# Rezoning Transportation Analysis

Petition Number: 2021-104

## Revision Log:

Date	Description
08-20-2021	First Review (KP)
09-17-2021	Second Review (WB)

Table with columns: FILE NUMBER: 8085-02, DATE: 04/12/2021, REZONING PETITION #2021-104 SCHEMATIC SITE PLAN, BEECHWOOD JACKSON, LLC, FERNCLIFF TOWNHOMES, and other project details.

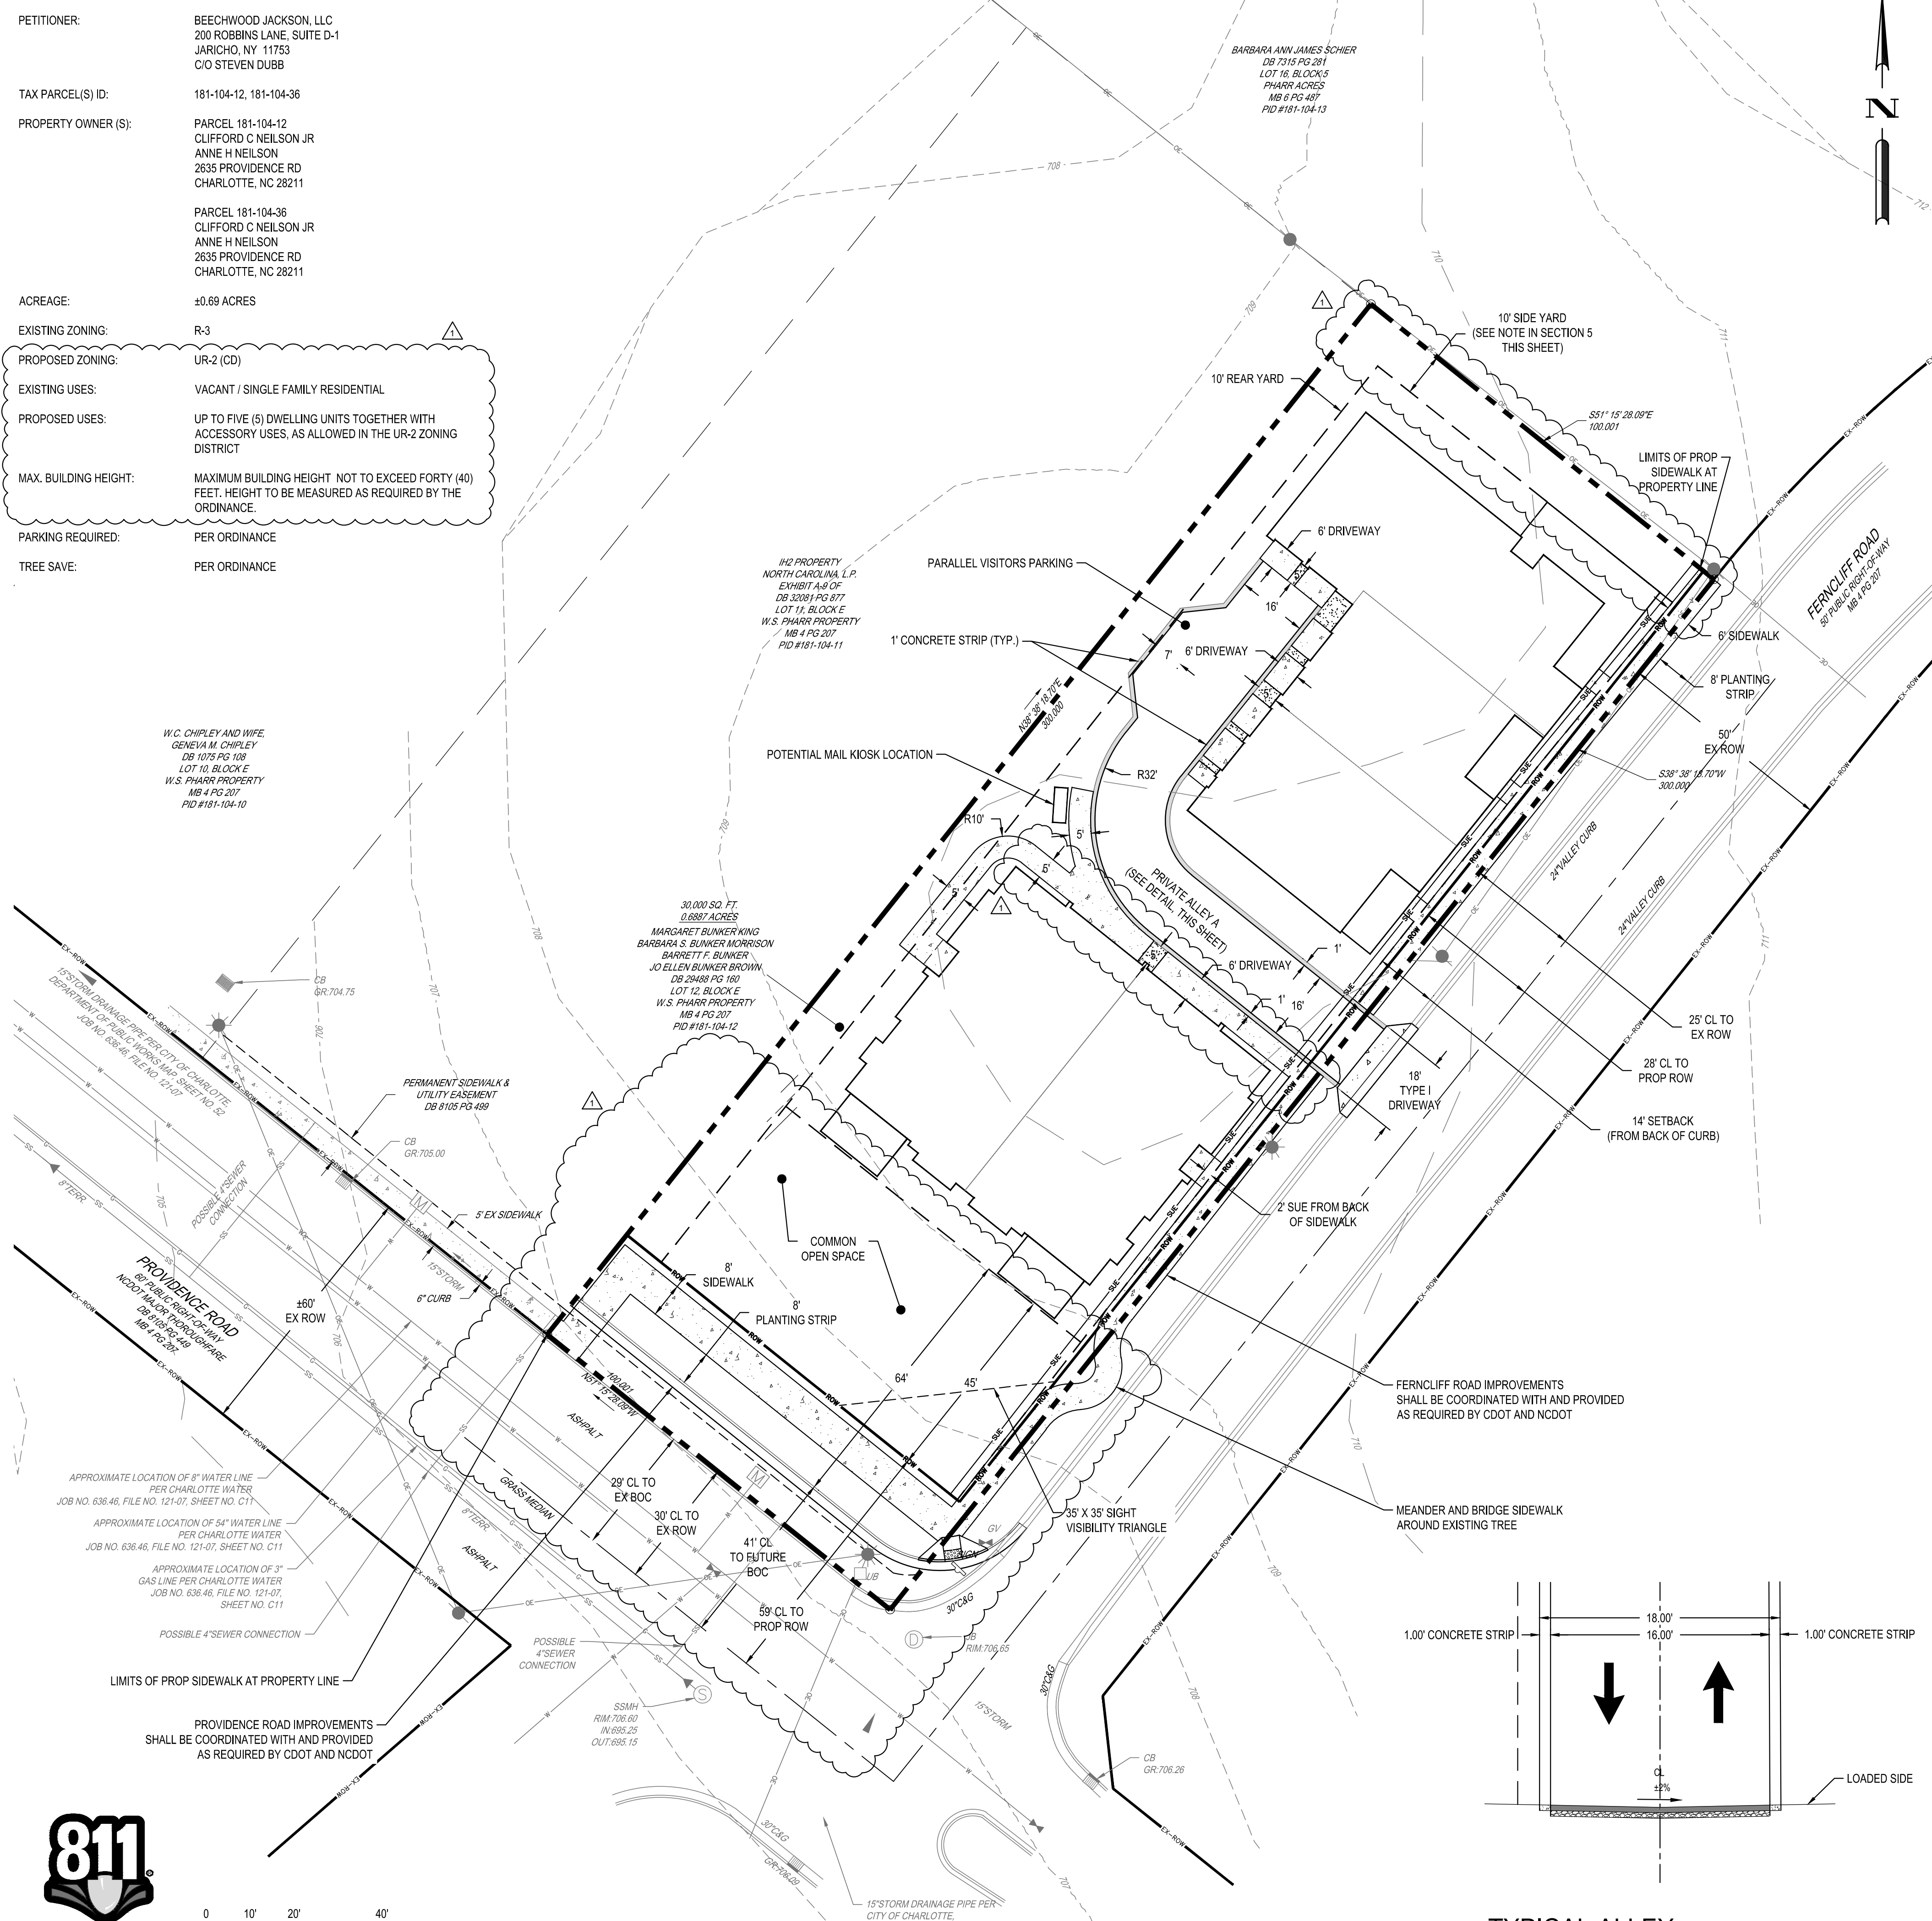
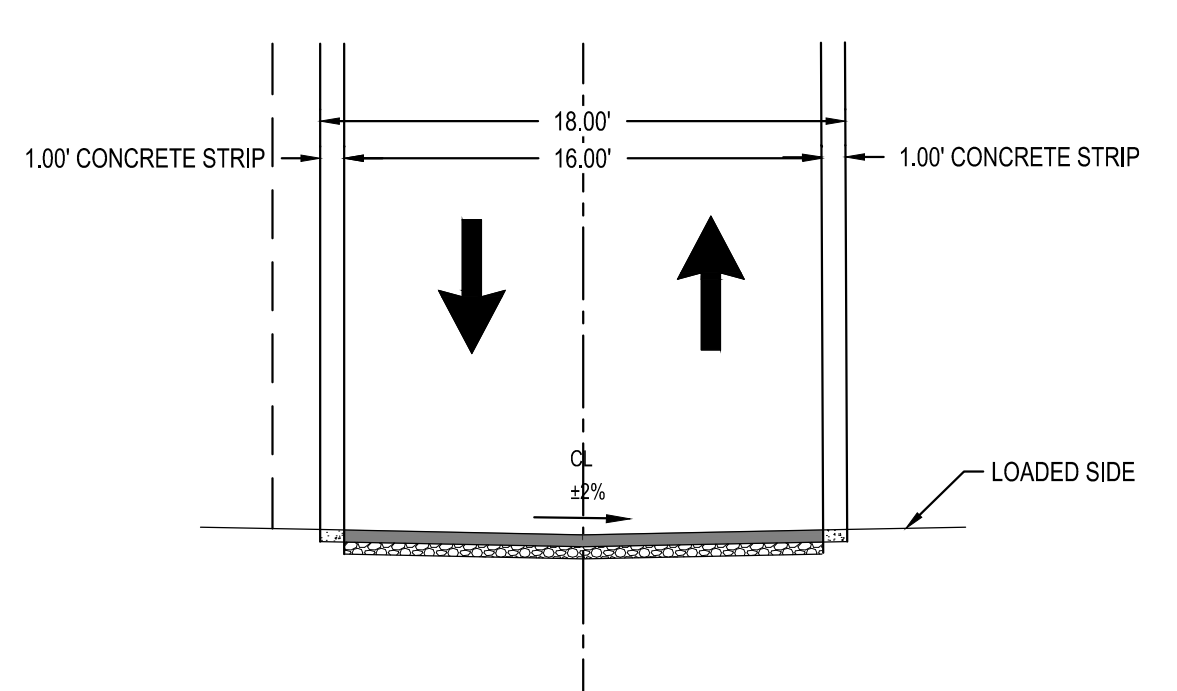
1. ~~**Curb line:** The proposed zoning district has a setback measured from back of the existing or proposed future curblines.~~
  - a. ~~**Ferncliff Road:** Location of curb and gutter may remain in it's existing location.~~
  - b. ~~**Providence Road:** The location of the future back of curb will be 41 feet from the existing centerline.~~

~~Label and dimension the existing and future back of curb from the centerline for each road on the site plan.~~

3. ~~**Right-of-way:**~~
  - a. ~~**Ferncliff Road:** Revise site plan and conditional note(s) to commit to dedicate 28 feet of right-of-way from the road centerline~~
  - b. ~~**Providence Road:** Revise site plan and conditional note(s) to commit to dedicate 59 feet of right-of-way from the road centerline.~~

~~The site plan shall label and dimension the right-of-way from the existing centerline of each road.~~

4. ~~Revise the site plan by placing the 8-foot sidewalk, along the site's frontage of Providence Road, relative to the future curb line located 41 feet from the existing centerline of Providence Road.~~

6. ~~Revise the site plan and conditional notes by committing to construct an ADA-compliant curb ramp, to cross Ferncliff Road, at the corner of Ferncliff Road and Providence Road.~~

7. ~~A site plan note(s) specifying dedication and fee simple conveyance of all rights-of-way to the City and/or NCDOT before the site's first building certificate of occupancy is issued is needed. CDOT requests rights-of-way set at 2' behind back of sidewalk where feasible.~~
